The Planning Inspectorate Temple Quay House Temple Quay Bristol Avon BS1 6PN Our ref: NA/2022/115883/02-L01 Your ref: NET ZERO TEESSIDE PROJECT CONS

**Date:** 23 June 2022

# EN010103: THE NET ZERO TEESSIDE NATIONALLY SIGNIFICANT INFRASTRUCTURE PROJECT. DEADLINE 2 SUBMISSIONS. LAND IN THE VICINITY OF THE SSI STEEL WORKS SITE, REDCAR, TEESSIDE, TS10 5QW

Sheet 4 of 4 - Elevations

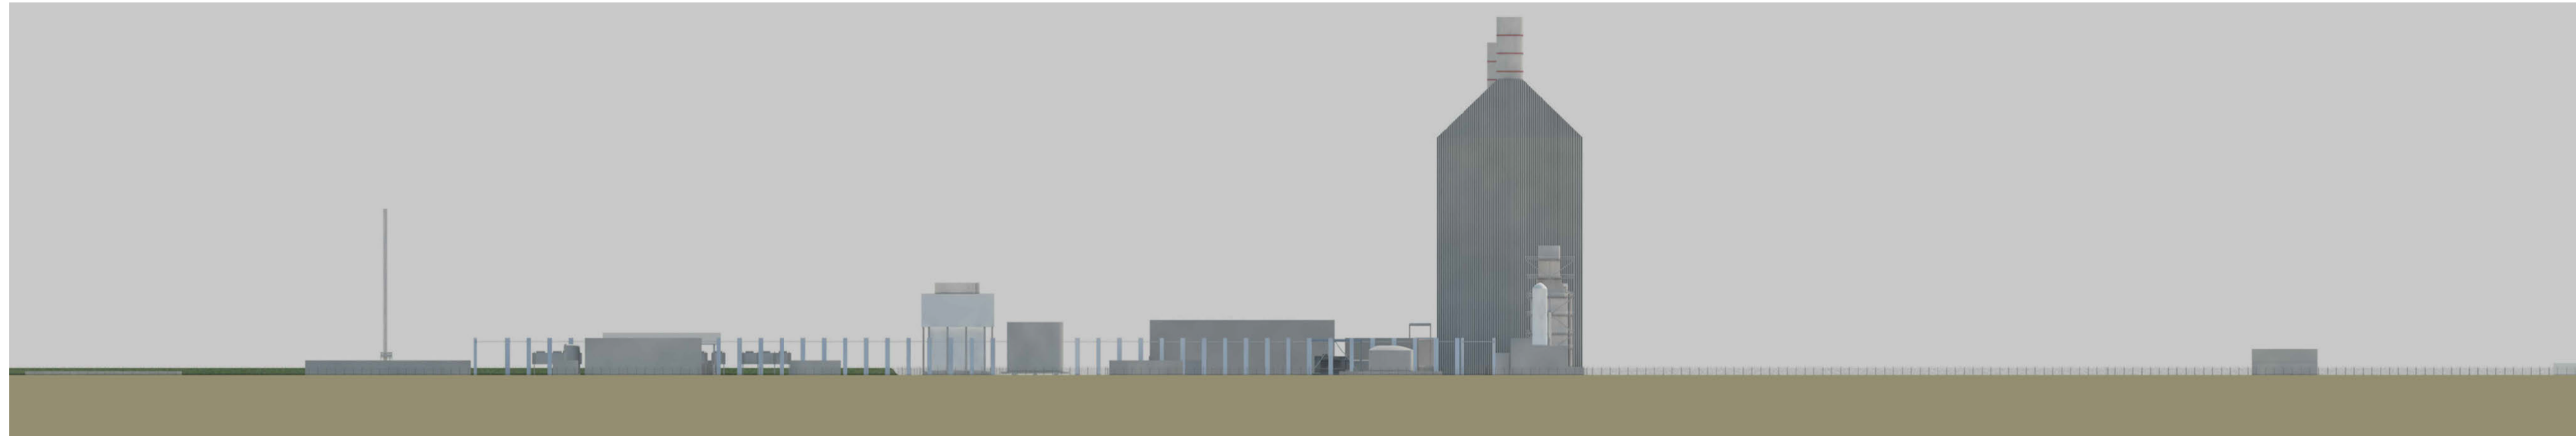
The Applicant proposes a Heat Recovery Stream Generation (HRSG) stack with an inner diameter of 6.5m. Representative monitoring of emissions from such a wide stack may prove technically difficult. Therefore an early review of the requirements of M1 monitoring guidance is recommended, as this may impact the final design and height.

The Applicant proposes an absorber stack with an inner diameter of 6.6m. Representative monitoring of emissions from such a wide stack may prove technically difficult therefore an early review of the requirements of M1 monitoring guidance for wet emissions is recommended, as this may impact the final design and height.

The Applicant's proposal to reduce the final stack height of the absorber and HRSG with a corresponding increase in stack width must be considered alongside the limited availability of air emissions monitoring equipment capable of sampling such wide stacks. An early review of the requirements of M1 monitoring guidance is recommended as this may impact the final stack design and height.
